# CITY OF ALBUQUERQUE

RE: First Christian Church, 10101 Montgomery Blvd. Grading and Drainage Plan Engineer's Stamp Dated 3-09-15 (File: F21-D080)

FIRST CHRISTIAN CHURCH	DRAWN BY DEM
		DATE J-2015
RICHARD H. DOURTE P.E. # 10854	GRADING & DRAINAGE PLAN CITY OF ALBUQUERQUE	FINAL CHURCH BUILDING
		SHEET # 4 of 6
		JOB # X000X

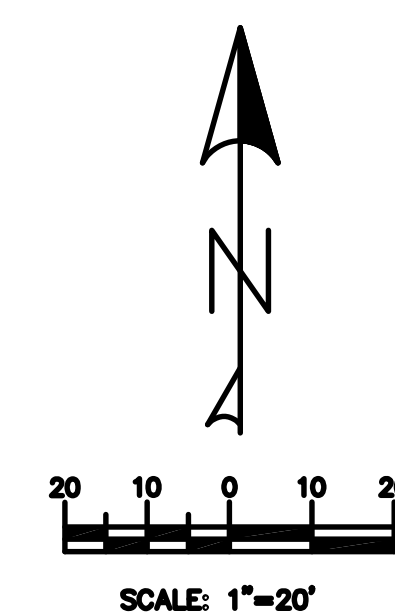
1) Show all new improvements that are contributing to the 0.13-acre increase in impervious area on the plan including the patio. Show elevation information for these new improvements.

2) For each of the proposed pipe runs, inlets, and sidewalk culverts, show capacity calculations. Label slope and flow that each pipe run is conveying.

3) The sidewalk culvert invert elevations and the neoplast area drain invert elevations appear to be 10 feet off. The culvert invert is also higher than the 12" HDPE pipe invert. Double-check these elevations, and revise as needed.

4) Label the existing curb and the existing sidewalk width. Call out COA Standard Dwg. 2236 for construction of the culverts. To prevent drop-off situation from sidewalk, extend sidewalk culvert 2 feet behind back of sidewalk. Show transition from 12" pipe to 2 sidewalk culverts.
